from
**Southern
Water**

Your ref
BR/107/21/PL

Proposal: Replacement of semi-detached buildings with terrace of 3 No. houses. This site is in CIL Zone4 & is CIL Liable as replacement dwellings.

Site: BR/107/21/PL: - 283-285 Chichester Road Bognor Regis PO21 5AH.

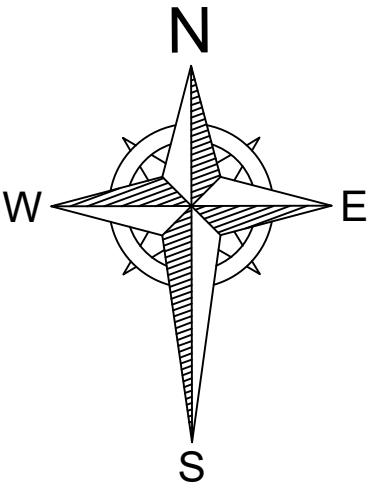
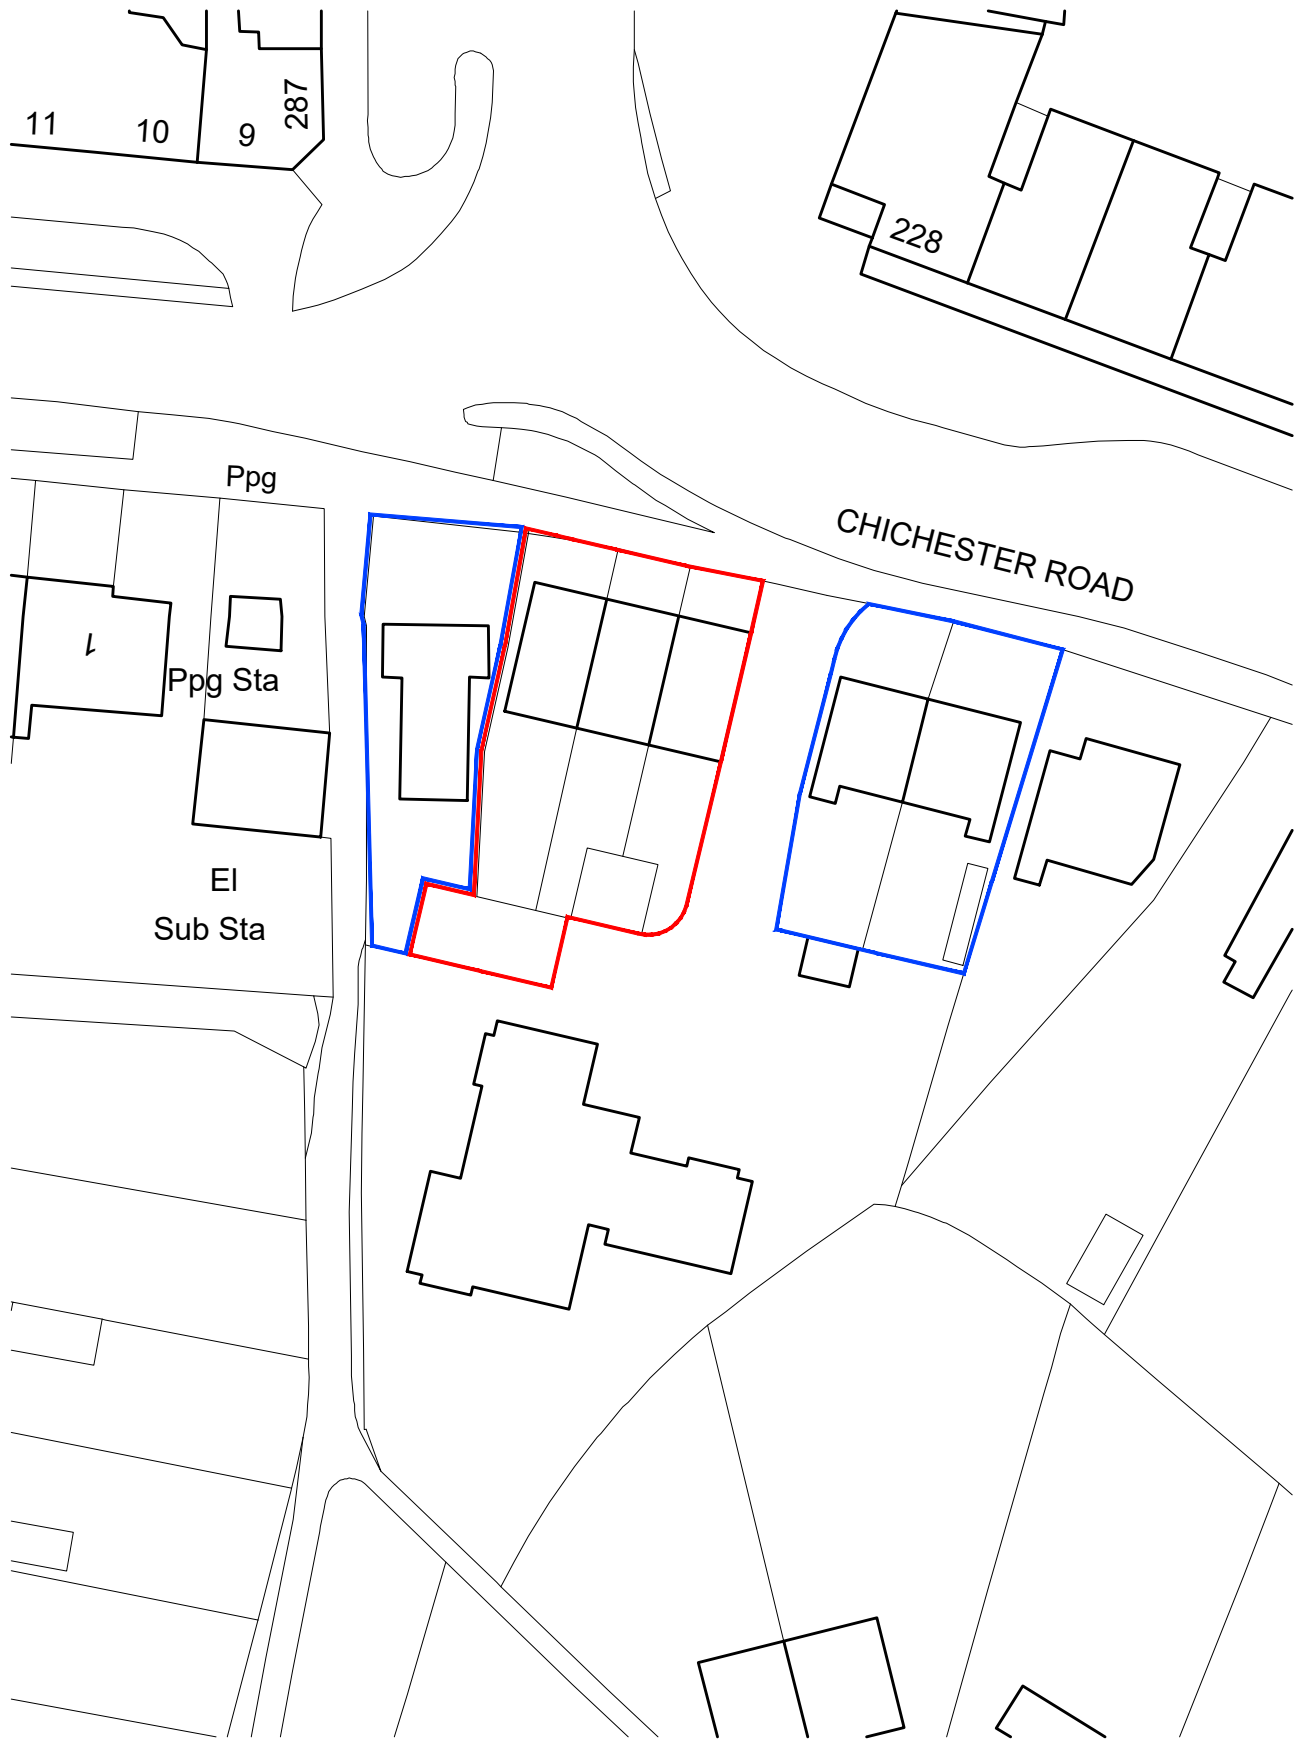
The attached plan shows that the proposed development will lie over an existing public foul sewer which will not be acceptable to Southern Water. The exact position of the public apparatus must be determined on site by the applicant before the layout of the proposed development is finalised.

It might be possible to divert the foul sewer, so long as this would result in no unacceptable loss of hydraulic capacity, and the work was carried out at the developer's expense to the satisfaction of Southern Water under the relevant statutory provisions.

- The public foul sewer requires a clearance of 3 metres on either side of the sewer to protect it from construction works and to allow for future access for maintenance.
- No development or tree planting should be carried out within 3 metres of the external edge of the public foul sewer without consent from Southern Water.
- No new soakaways should be located within 5 metres of a public sewer and rising main.
- All existing infrastructure should be protected during the course of construction works.

Alternatively, the applicant may wish to amend the site layout, or combine a diversion with amendment of the site layout. If the applicant would prefer to advance these options, items above also apply.
